Recommendation Report for Planning Permission for Works or Extension to a Dwelling

REF NO: AW/224/12/

LOCATION: 3 Apple Grove
Bognor Regis

PROPOSAL: Proposed single storey rear & side extension, new front & rear dormer windows & internal alterations (this application is a dual parish with Pagham) re-submission following AW/134/12/

PROPOSED FRONT / SOUTH-EAST ELEVATION
BD494 PE01-1

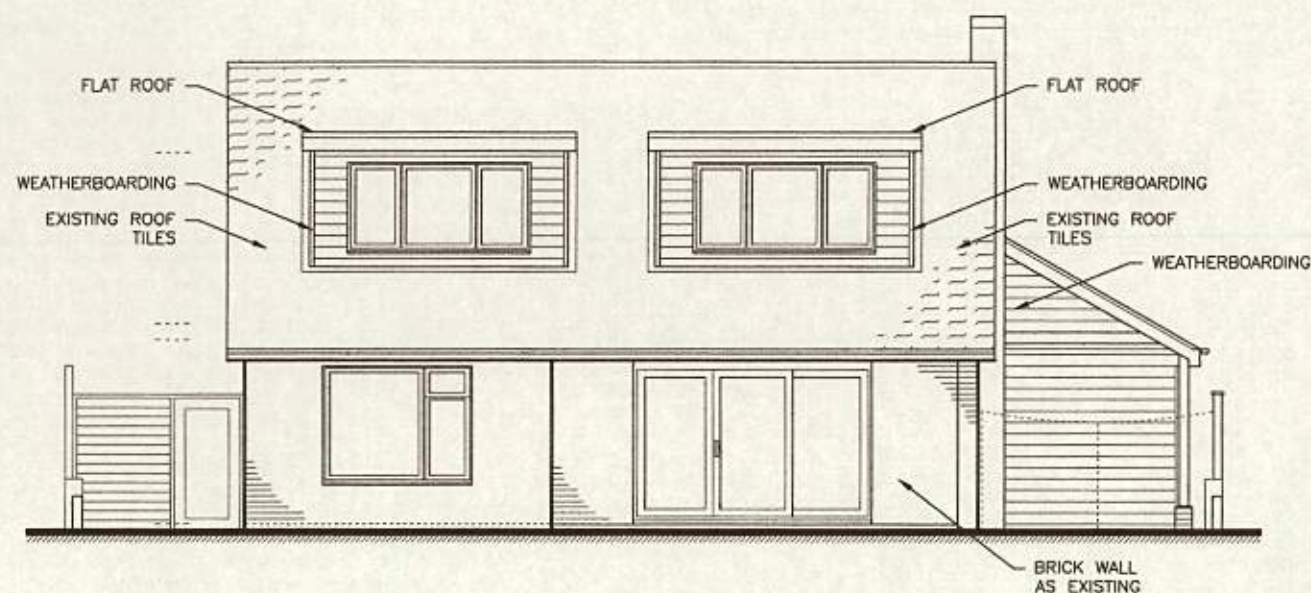
The proposal is a re-submission of a previously refused application AW/134/12. The extensions and rear dormer were considered to be of an acceptable size but the application was refused on the basis that the front dormer by reason of its size and design would appear out of character within the street scene. The application as submitted has replaced the single dormer with two flat roof dormers.

The front dormers are now considered to be of an acceptable size and height that do not detract from the host dwelling. There is an existing rear dormer and it is not considered that the extended dormer which serves a bedroom and bathroom would create any unacceptable overlooking than currently exists. The proposal has a window at first floor level on the west side elevation and, if approved, this will be conditioned to be obscure glazed.

PROPOSED REAR / NORTH-WEST ELEVATION
BD494 PE01-3

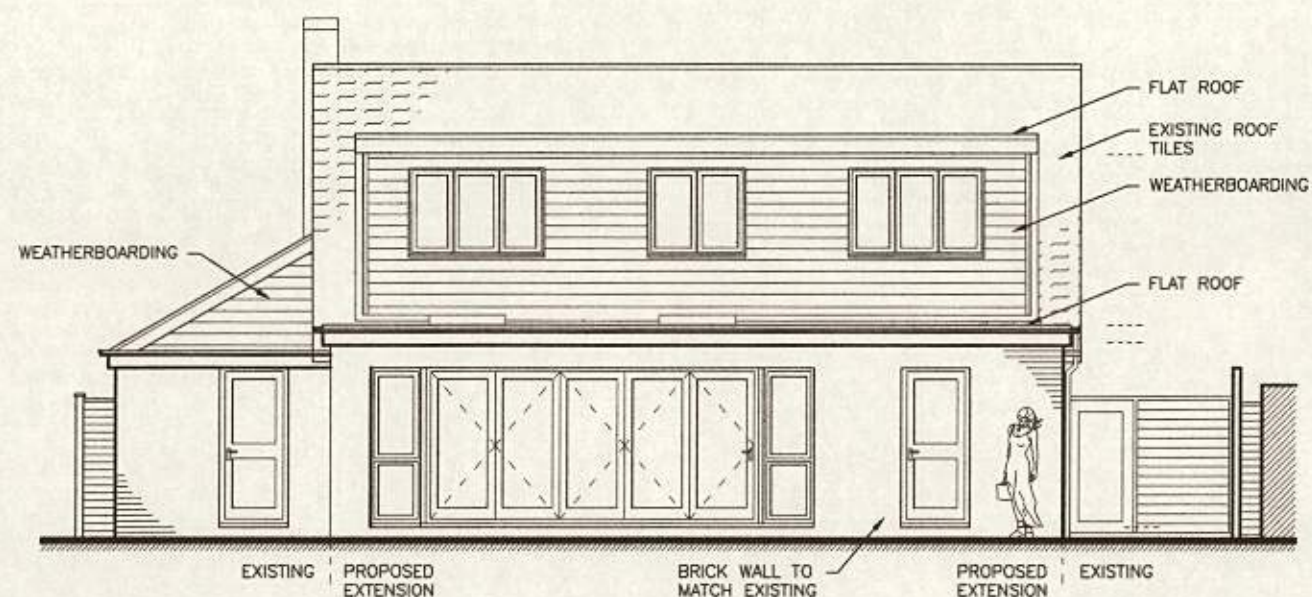
The rear conservatory is to be removed with part of the kitchen and the proposed single storey flat roof addition will extend along the full width of the building. The existing garage is to be removed and the new garage/store will be sited adjacent to the rear extension. The front porch which is open in appearance will be set back from the front of the dwelling by approximately 1.5m. The rear dormer has been reduced in height which is the same height as the front dormers.

PROPOSED SOUTH-WEST ELEVATION
BD494 PE01-4

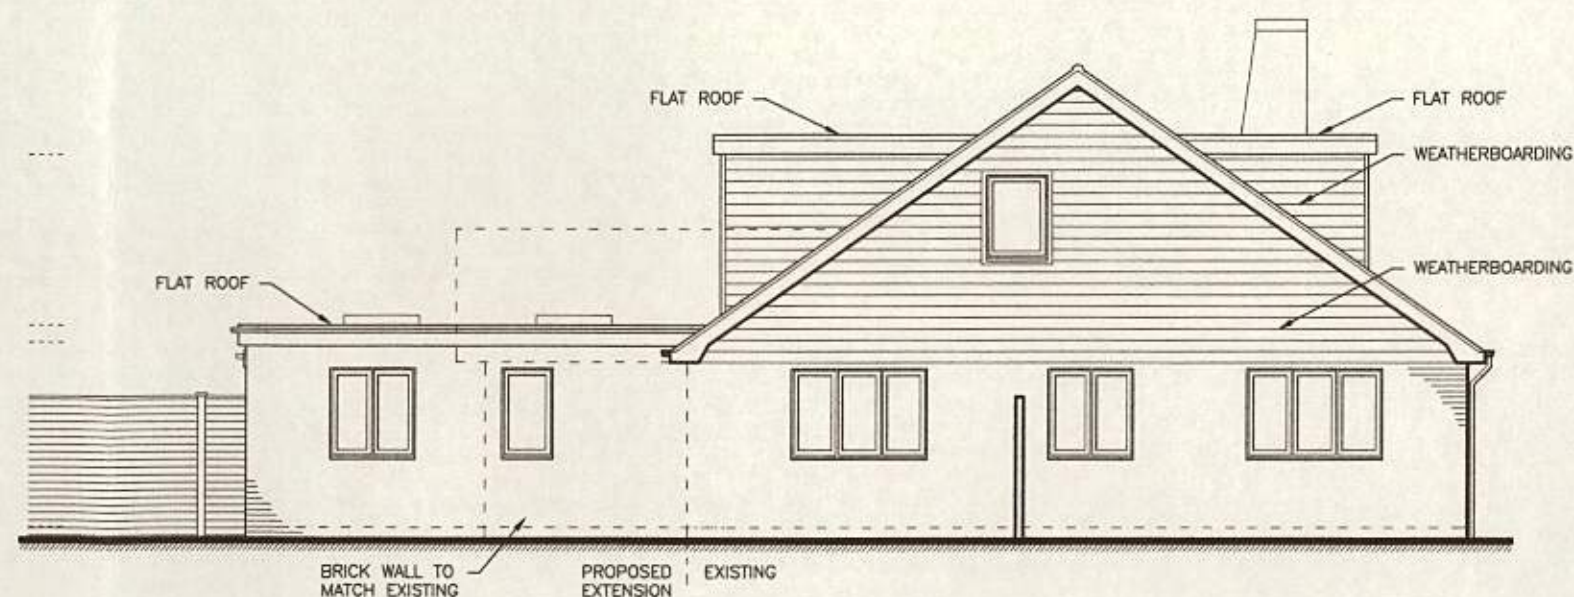
With regard to residential amenity the neighbouring property to the east No 2 is sited approximately 3m away and to the west No 4 5m away. No 4 has windows on the east side elevation at ground floor level which is an ancillary lounge window, kitchen window and door. There is an obscure glazed window at first floor level which serves a wc. No 2 has the entrance door on the west side elevation which is set forward of the side extension and this is sited approximately 3m away. This property has a conservatory on the rear and this is sited approximately 3.5m away. Although the extensions will be visible above the side boundaries by approximately 1m it is not considered that this would be of an overbearing affect or create loss of

- 3 The bathroom window at first floor level on the south west elevation of the building and the en-suite window on the rear dormer extension shall at all times be glazed with obscured glass.
